**RE: Sydney Grammar School, Weigall Sports Complex: State Significant Development (SSD-10421):  
Response to Condition B1**

This letter on the Sydney Grammar School Weigall Sports Complex (SSD-10421) is written on behalf of Sydney Grammar School. It responds to SSD-10421 Condition B1 which states:

- B1. Prior to the issue of any construction certificate, the design of Building 1 (Sports Complex building) must be amended and revised architectural plans and documentation demonstrating compliance with the condition must be submitted to, and approved by, the Planning Secretary. The revised design must modify the design of that part of Building 1 located directly opposite 8 Vialoux Avenue (i.e. the building component east of the Building 1 stair core/Multipurpose Hall 4 and including the area above the program pool) to reduce the view loss impact experienced by the north facing living rooms within apartments 1, 5, 8 and 12 at 8 Vialoux Avenue. The amendments to the design must comprise (unless otherwise agreed with the Planning Secretary) the following:

ROOF PLAN
RESPONSE TO CONDITION B1

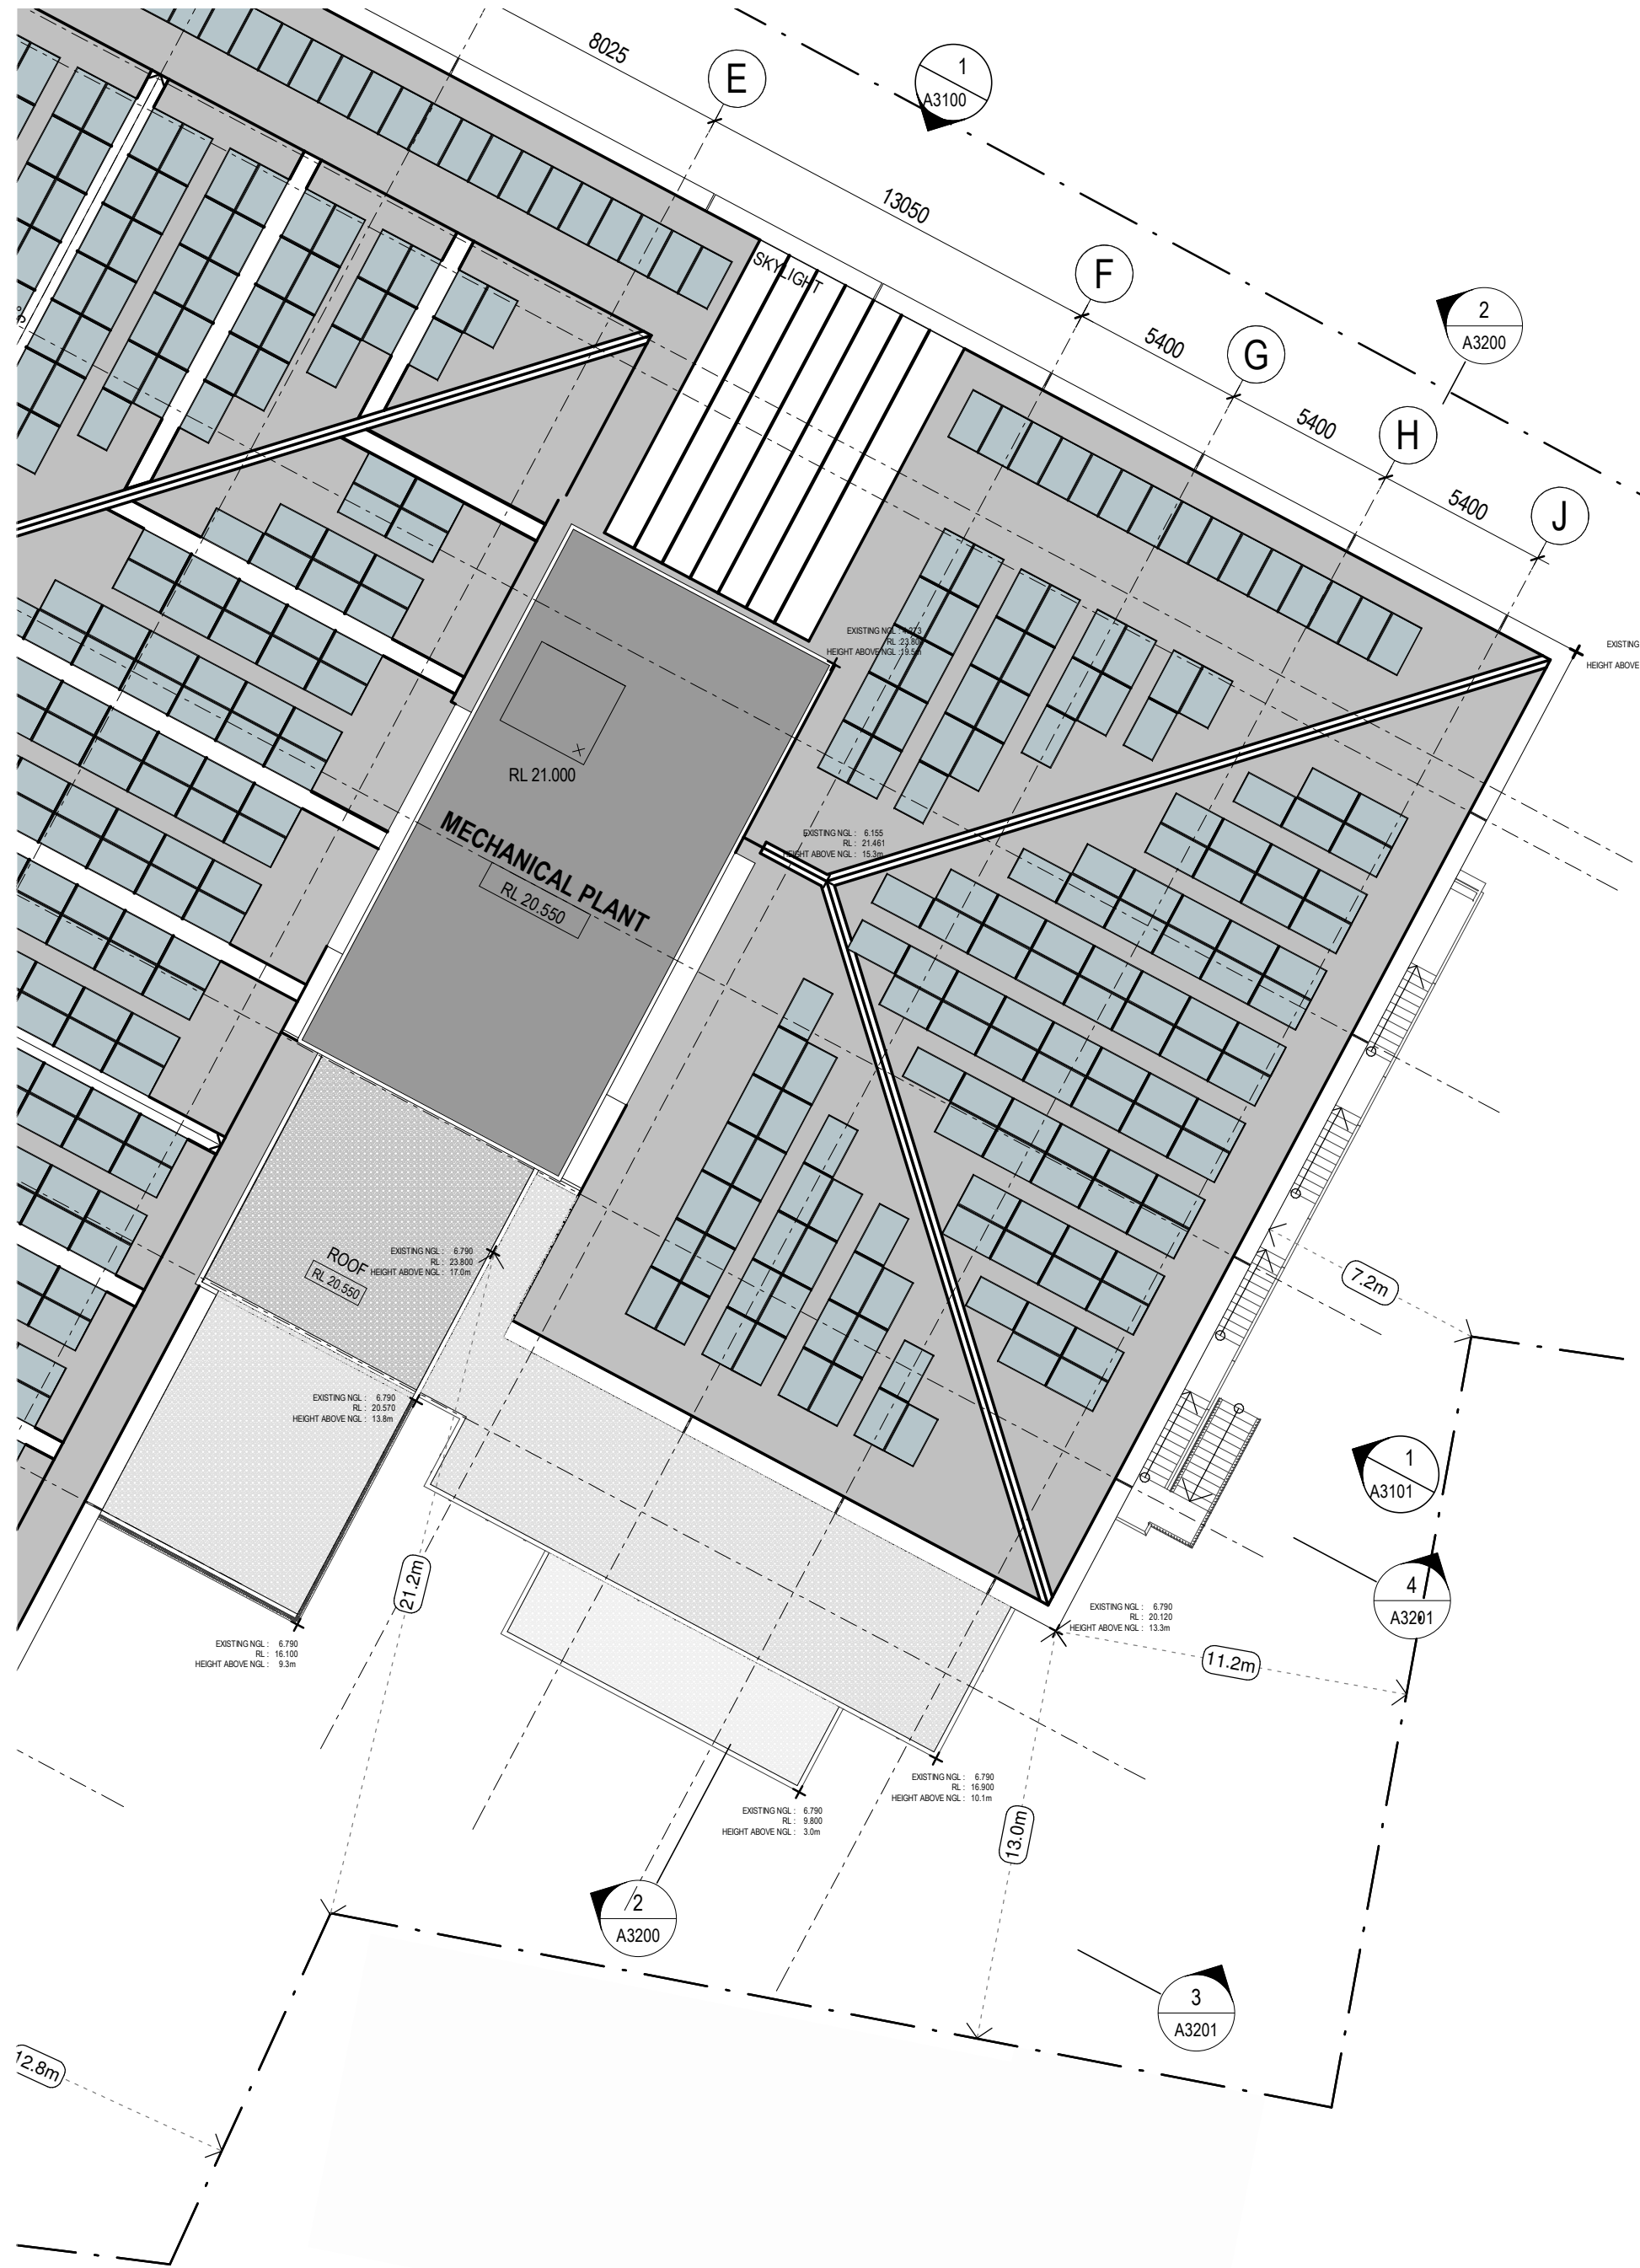
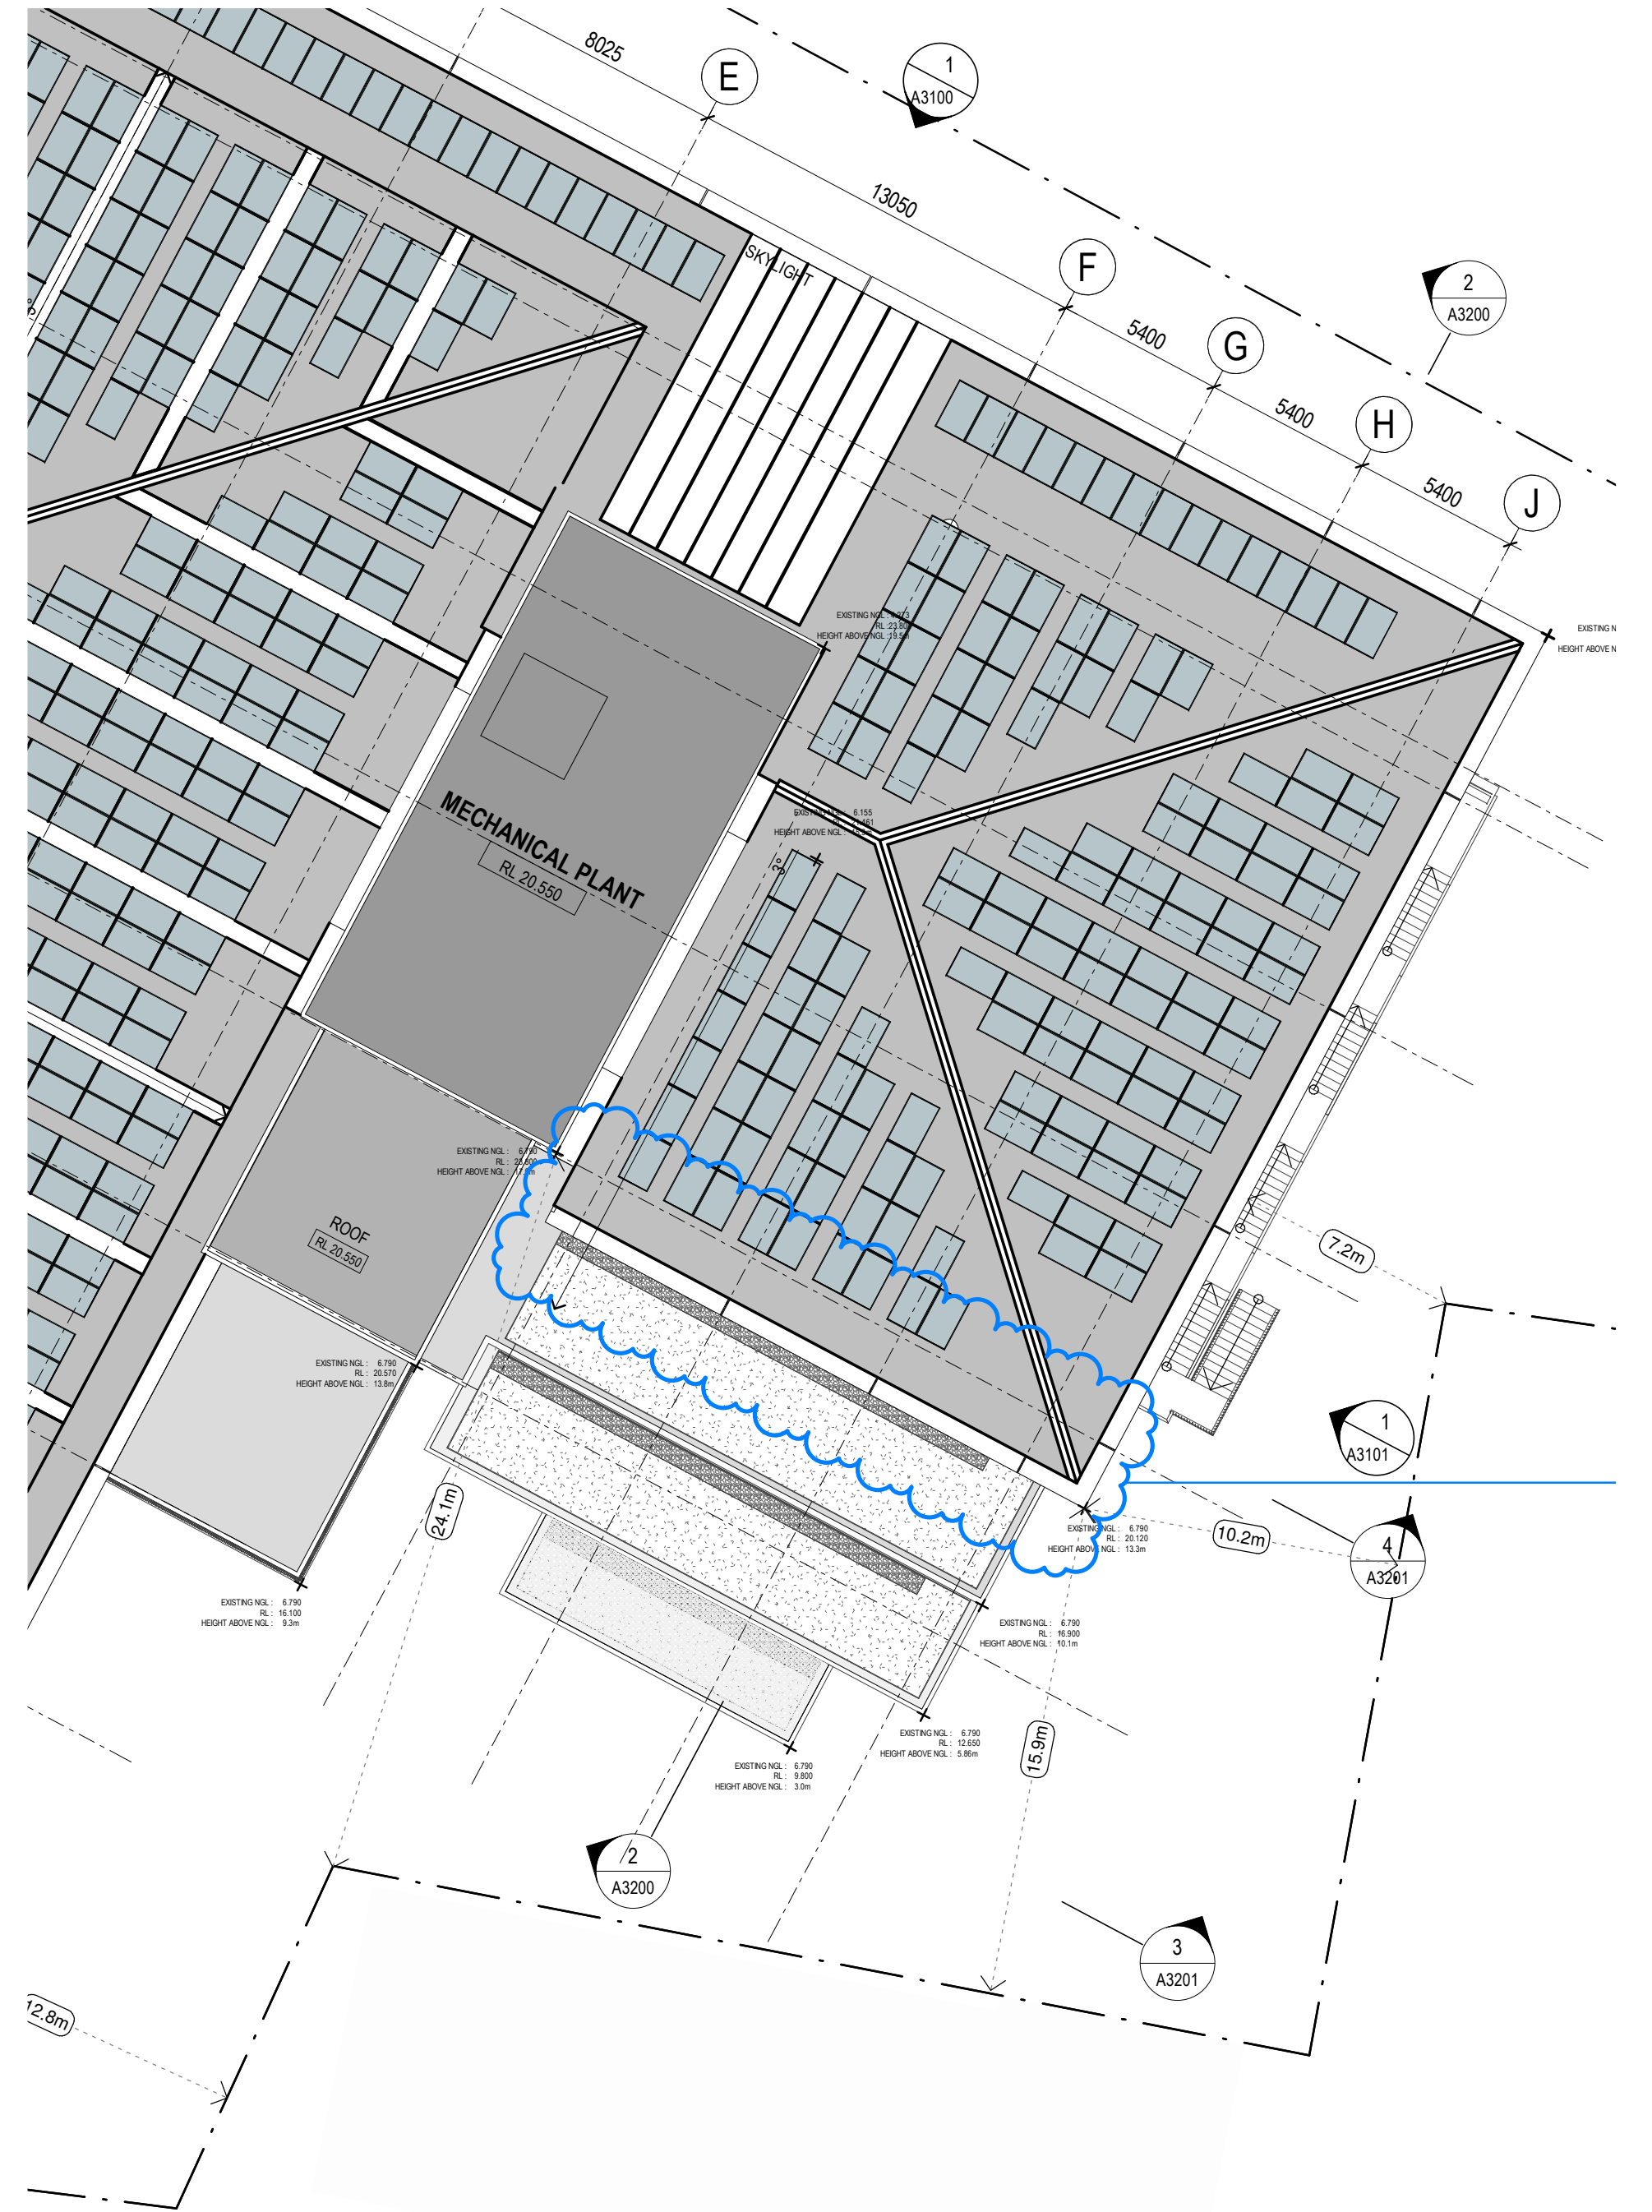
4. Roof Plan is reduced to reflect the Level 1 and 2 southern boundary setback (Design Amendments 1, 2 and 3). The northern section of the Roof Plan does not change
